CITY OF ALBUQUERQUE

March 2, 2017

**Re: Rohan Subdivision
Erosion and Sediment Control Plan
Engineer's Stamp Date 1-26-17 (C19E042A)**

EROSION AND SEDIMENT CONTROL PLAN

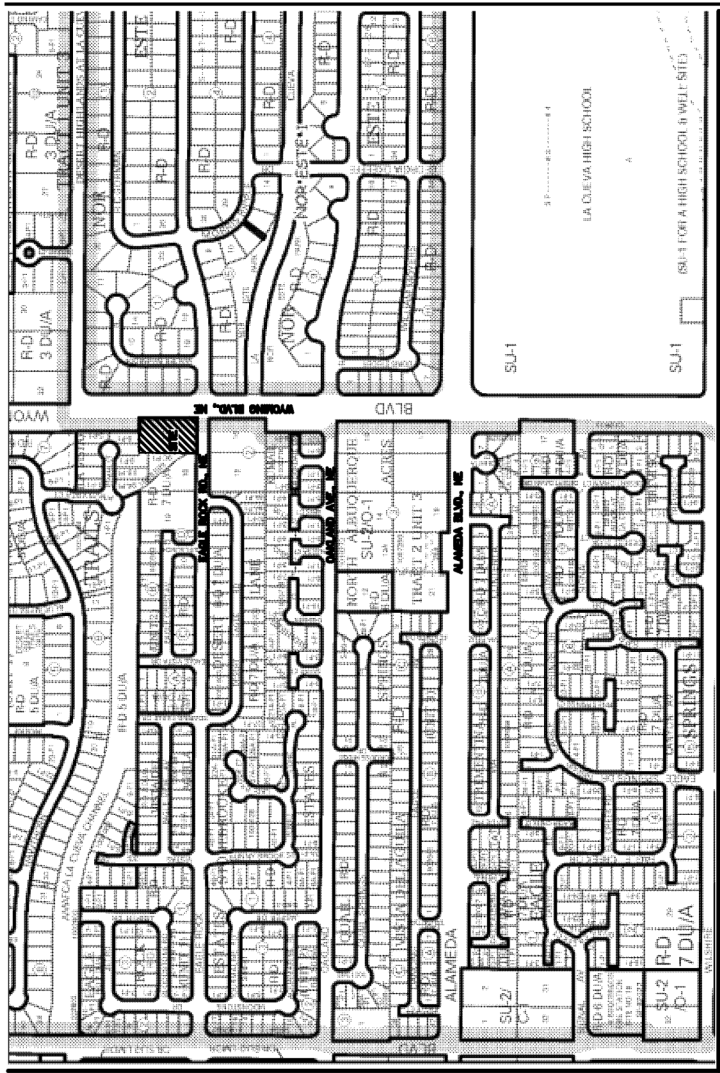
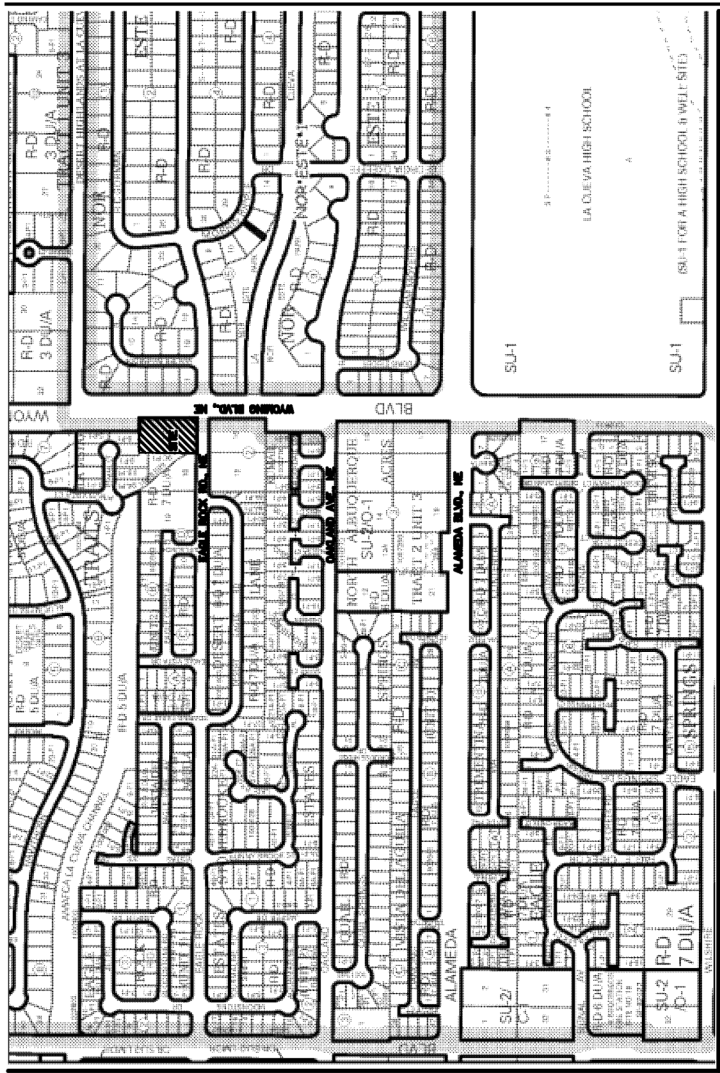
1. Since the west half of Wyoming Blvd is to be constructed, prior a wattle or similar at the north end of the project.
2. Curb and gutter is to be built on Eagle Rock Rd west of the site. Provide a sediment BMP for the grading associated with this work and inlet protection on the inlet adjacent to the curb and gutter work.
